Subject: VA-26-00001 Regan

Thank you for the opportunity to respond to the comments submitted regarding Variance Application VA-26-00001 – Regan Setback.

Regan, Tracy
1011 Sky Meadows Dr., Cle Elum, WA
Parcel ID: 116734
Map #: 19-16-17050-0003

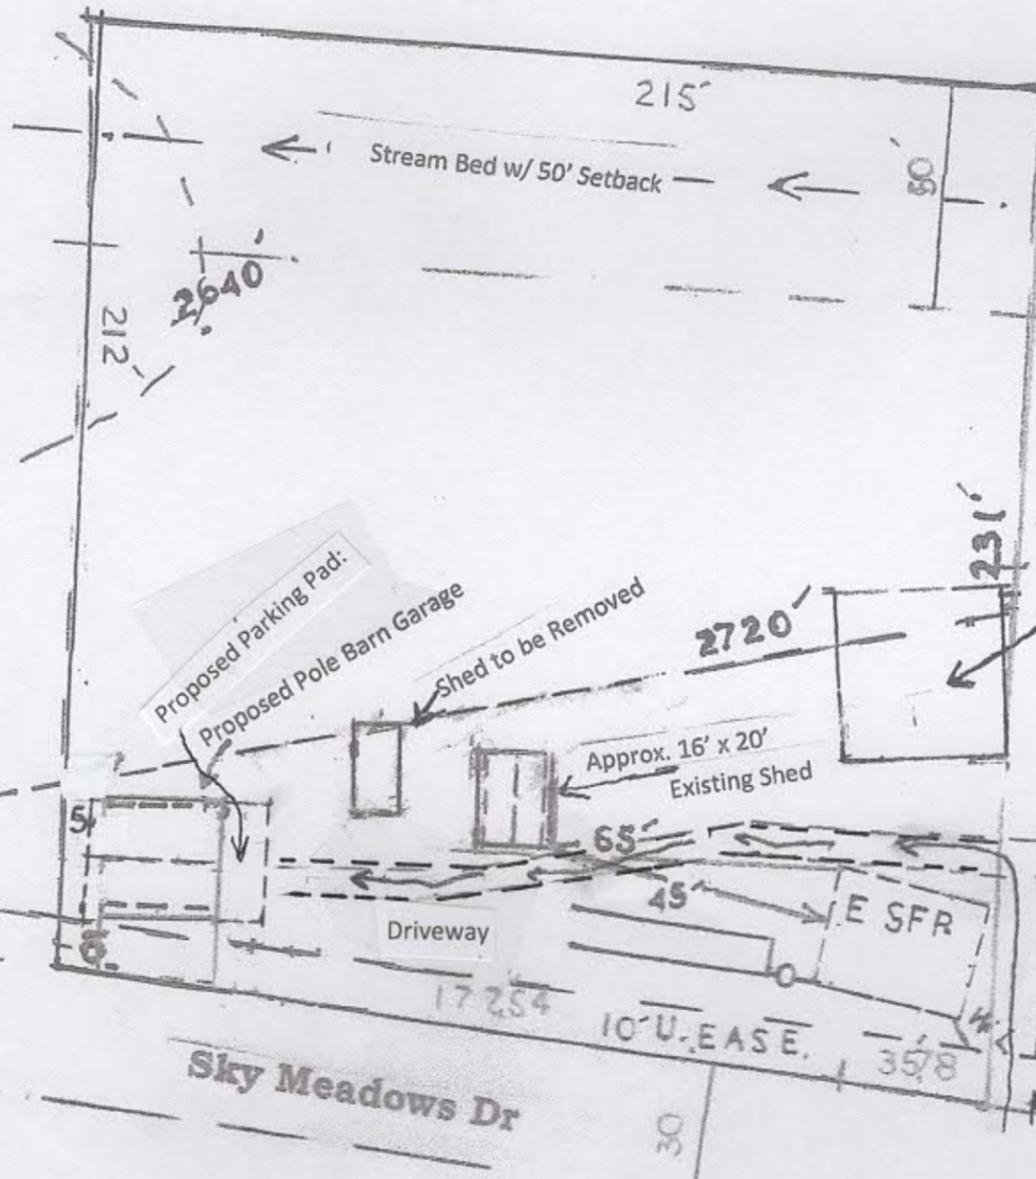
After further review of the site constraints and the concerns raised by the reviewing agencies, the variance request has been reduced from the original proposal. We are now requesting only:

- a 5-foot variance to the front setback, and
- a 3-foot variance to the side setback.

This would decrease the setback from the 25' to 20' and the site setback from 15' to 12. This represents a substantial reduction from the original request and reflects a good-faith effort to minimize encroachment while still allowing reasonable use of the property. The revised request is also consistent with the requirements outlined in the applicable Community Covenants, which are attached for your review.
